History:

New Mills Marsden is a former cotton & woollen mill constructed around 1897 for the firm J E Crowther and Sons

Assessment of proposals

## Plaza - Detail Area

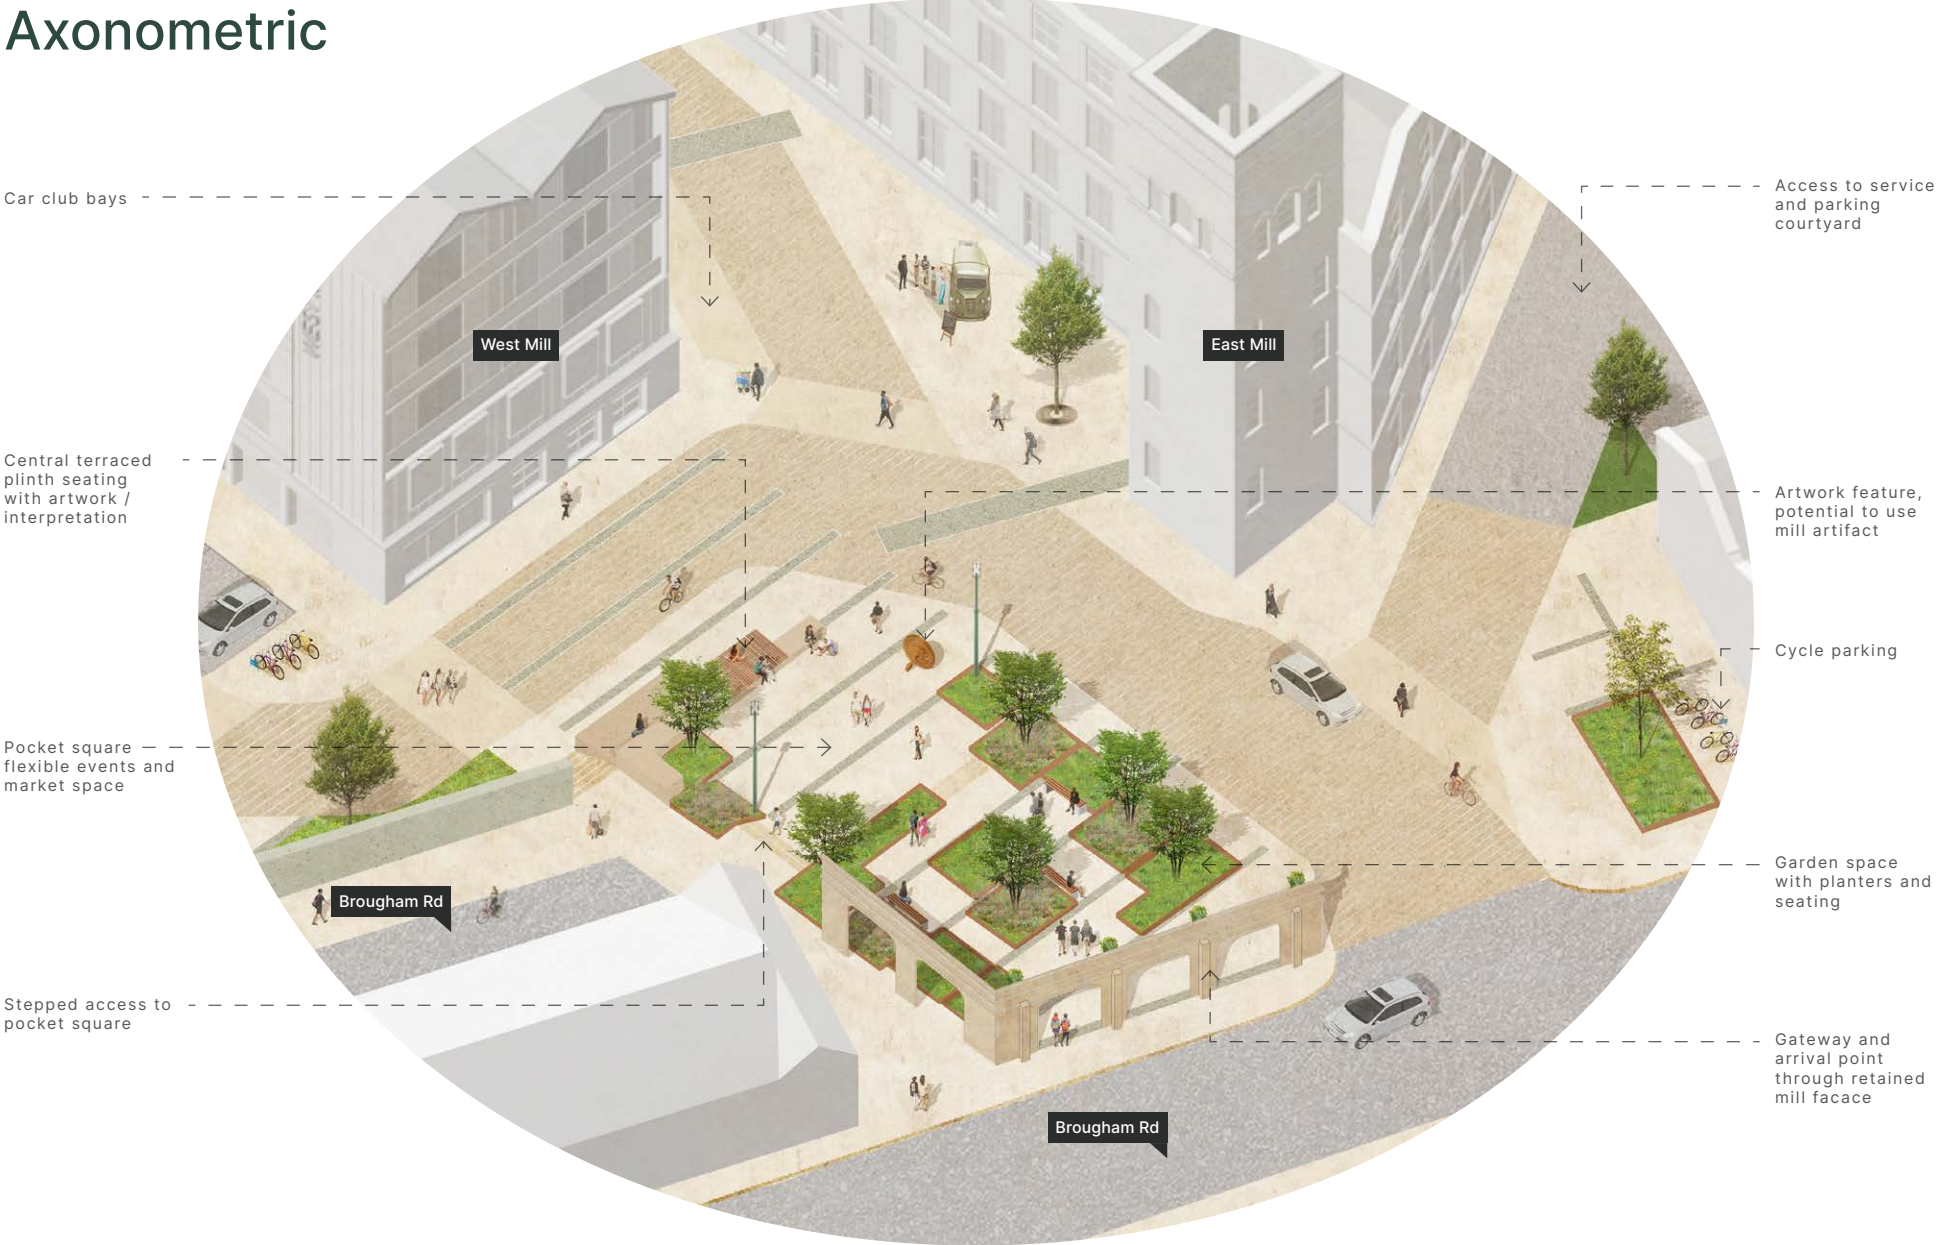
The NPPF requires that where demolition is proposed which would impact a heritage asset, local planning authorities should not permit the loss of the whole or part of a heritage asset without taking all reasonable steps to ensure the new development will proceed after the loss has occurred. The proposed demolition of the southern section of the West Mill is regrettable but may potentially be justified and so in order to fully satisfy the requirements of national heritage policy under NPPF paragraph 217 every effort should be made to ensure that a suitable replacement building or space of either architectural/landscape merit is secured. Whilst KC Conservation and Design understands the rationale for the retention of some of the façade of the former wages office, having liaised with the council's highways department it would appear that in reality very little of this structure could in fact be retained for highway safety reasons and thus its overall architectural/historic legibility would be lost, diluting the design intent. As such, it is considered that this is not the most appropriate solution/design for this space and KC Conservation and Design would welcome further dialogue with the applicant team and landscape architects to discuss alternative options.

From a conservation and design perspective, it is considered necessary to reinforce the strong and uniform building line along Brougham Road, as is the urban grain and legibility of space between Derby Terrace and the West Mill. In this instance, it is considered that some form of structure or boundary treatment along Brougham Road is critical.
